Consultation Response from KC Highways Development Management		
2026/90619 United Church Marsden, Warehouse Hill Road, Marsden, Huddersfield, HD7 6AB		
Change of use and alterations to church (Class F1) and Sunday school to form 8 residential units (Class C3) including internal reconfiguration and external alterations, insertion of rooflights and formation of roof terrace, associated parking, landscaping and ancillary work (within a conservation area)		
Date Responded: 30/03/26	Responding Officer: M Zenner	Responding Ref: K1-8/14

RECOMMENDATION: No objection in principle to the proposals, some minor amendments should be undertaken.

Proposed Ground Floor Plan

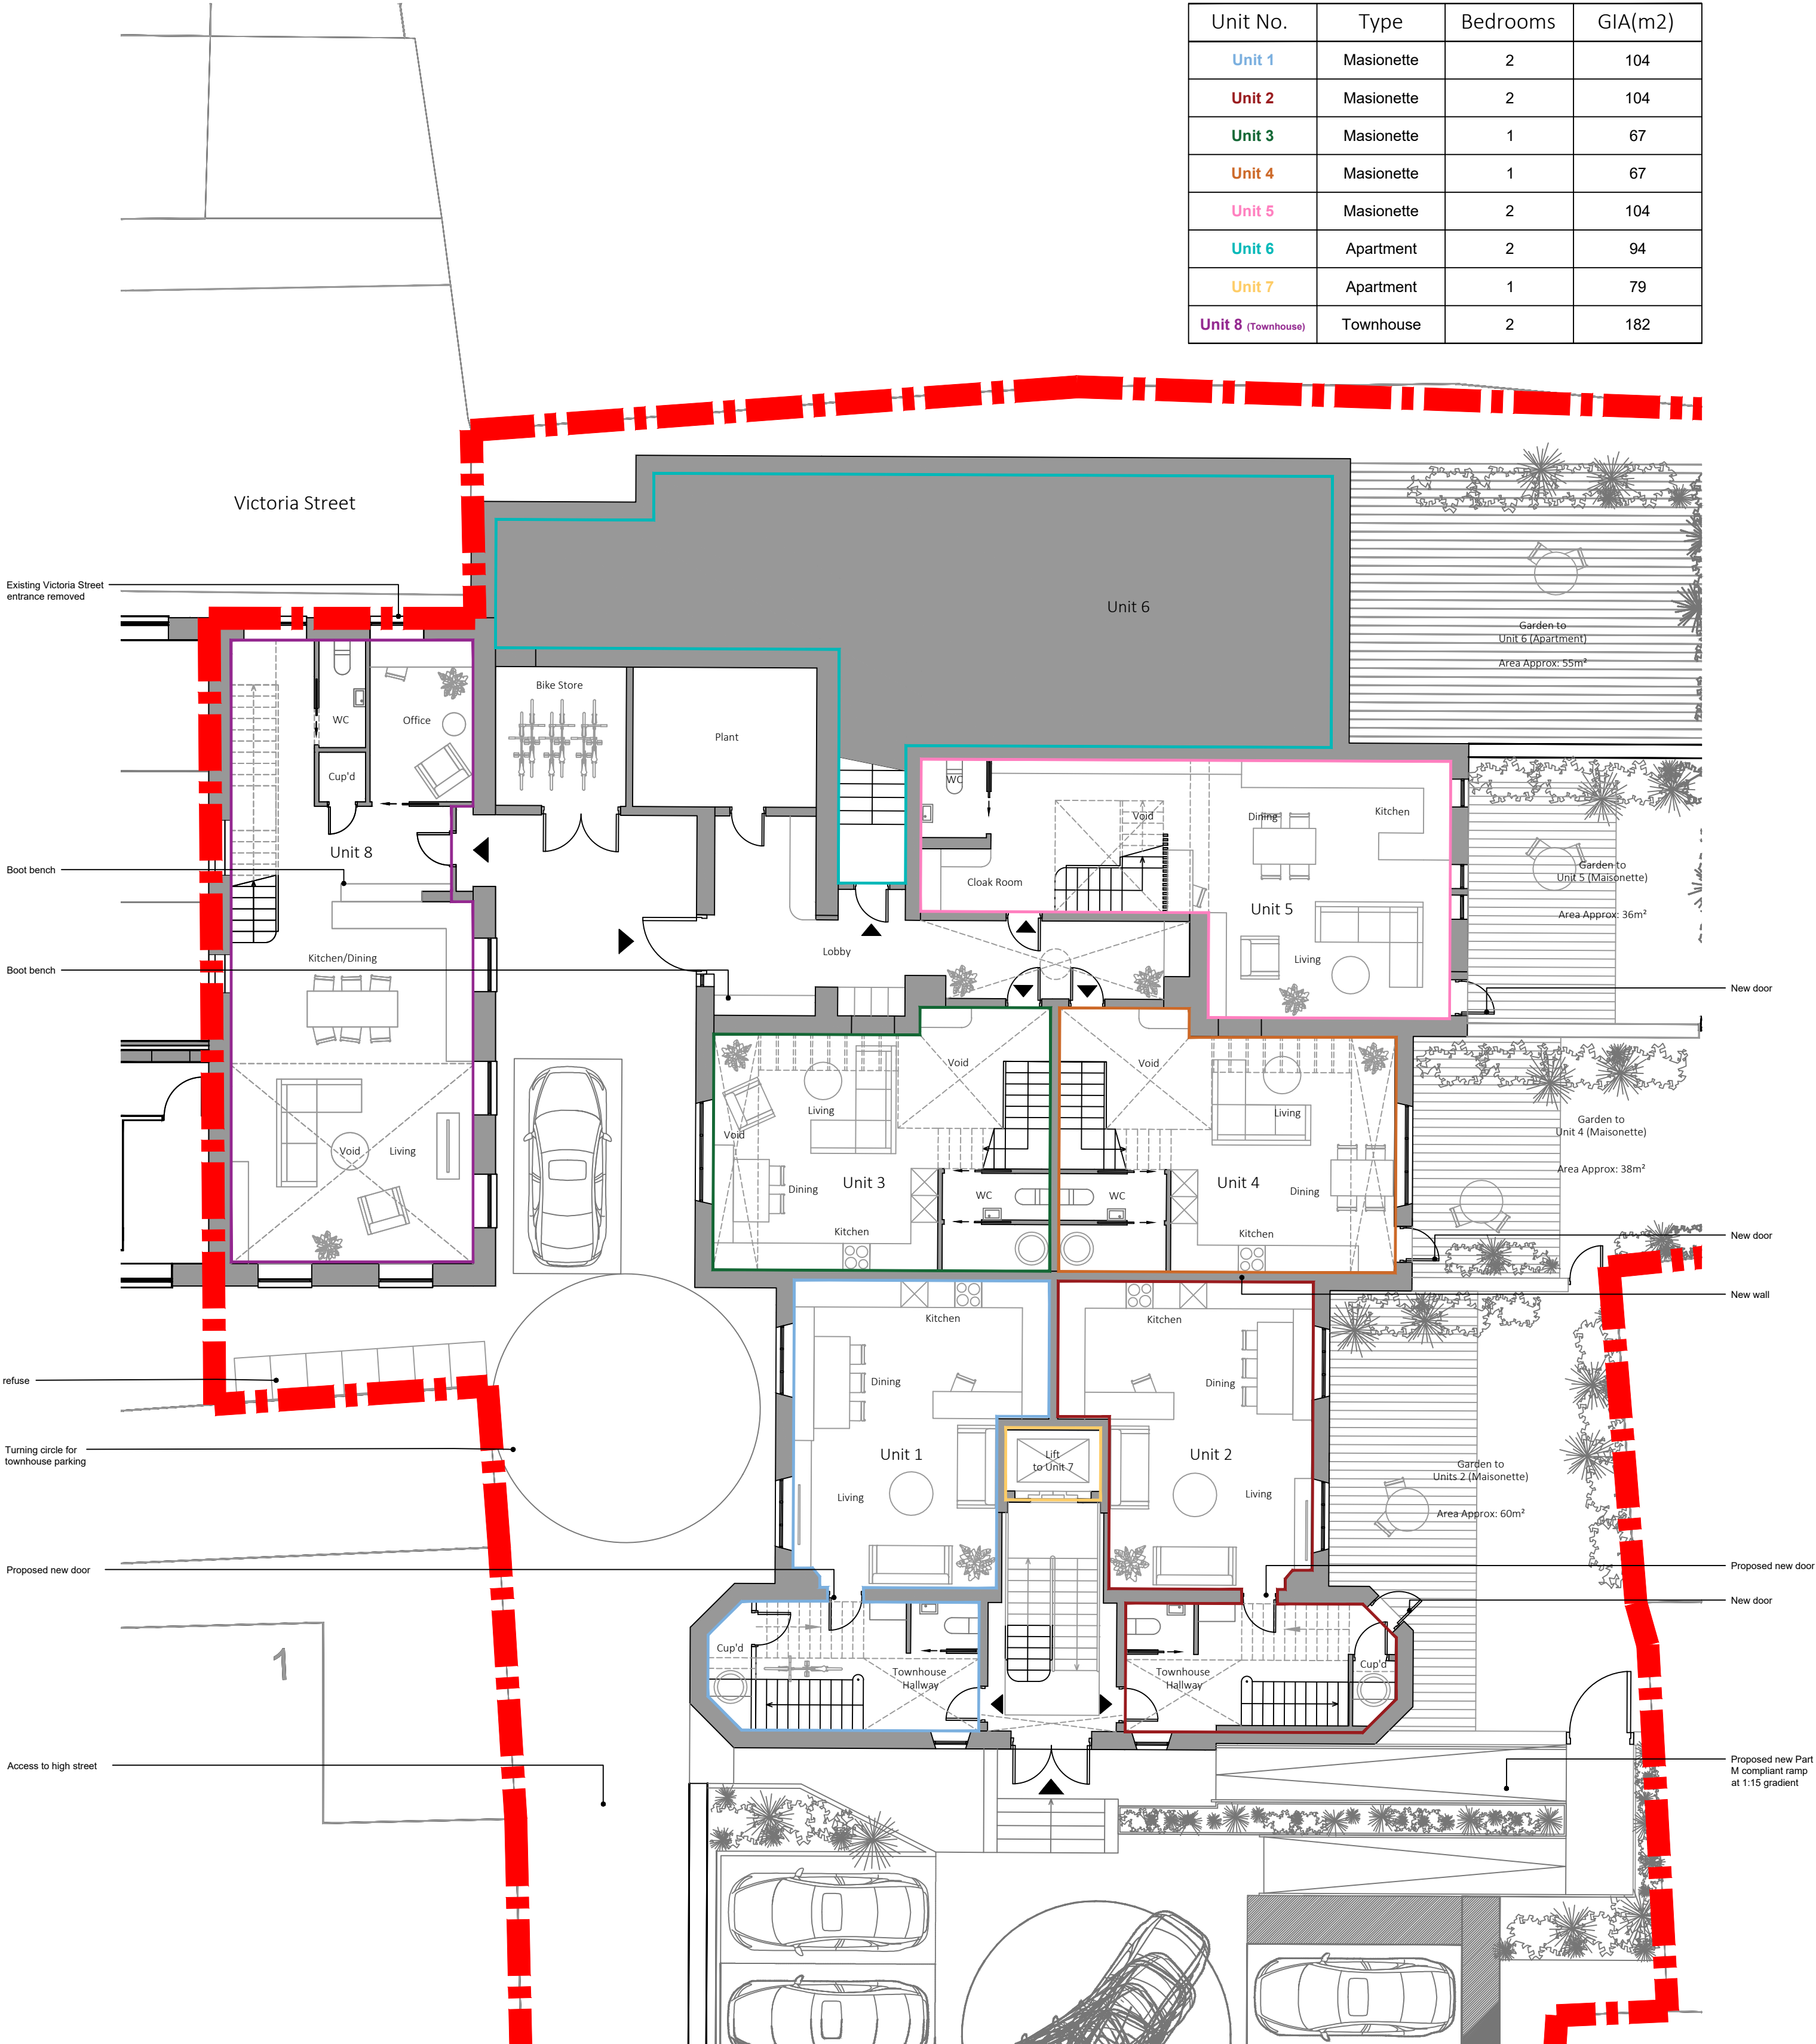
Pedestrian access appears to be from the same access points as the vehicular accesses and are as existing. The proposals look to install a 1:15 ramp to the front entrance to the property. There is also pedestrian access proposed to units 3,4,5 and 6 from the side access to the property. The location of the parking space 9 does reduce the available footway width to approximately 1.6m at this point which could benefit from being increased to 2m, especially noting that the cycle store is also located within this area also and access and egress for cyclists will also use this route.

The provision of 9 car parking spaces are provided for the development, one space is shown adjacent to unit 8 and 8 car parking spaces are provided for the development in the car park to the front of the church building. One of the spaces is accessible, however, it is noted that the circulation aisles required for the accessible space need to be increased in size to 1.2m to the side and rear of the space.

title:
Proposed Site & Roof Plan

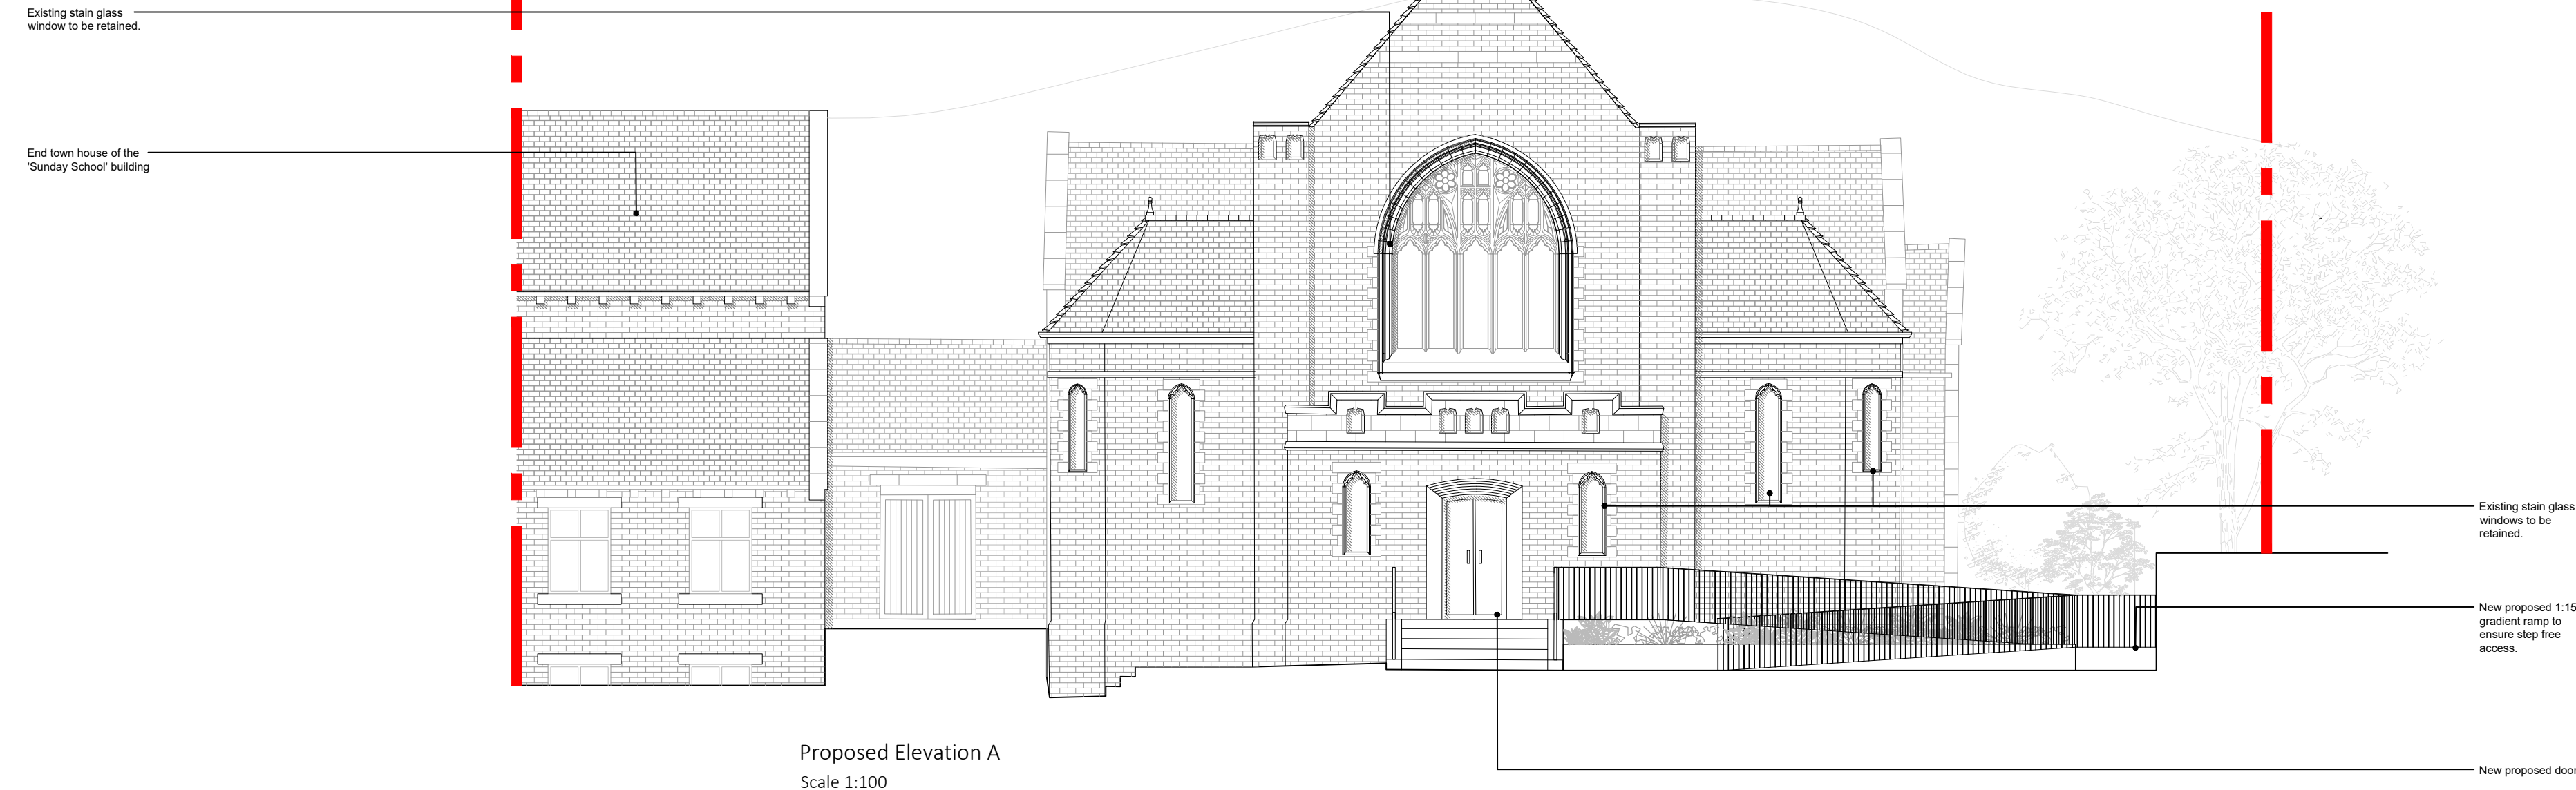
The proposed vehicular access appears to be approximately 4.6m wide on the 'proposed site and roof plan', this would be wide enough to provide simultaneous access and egress. However, it is noted that the plan also states that the existing access point to the church car park is to be retained. The existing access does not appear wide enough to allow simultaneous access and egress. Whilst an access that allows simultaneous access and egress would be beneficial, it is accepted that the existing car park entrance has worked acceptably for many years and the proposals only look to increase the number of spaces within the site by two, which is unlikely to have an impact in the LHA's view.
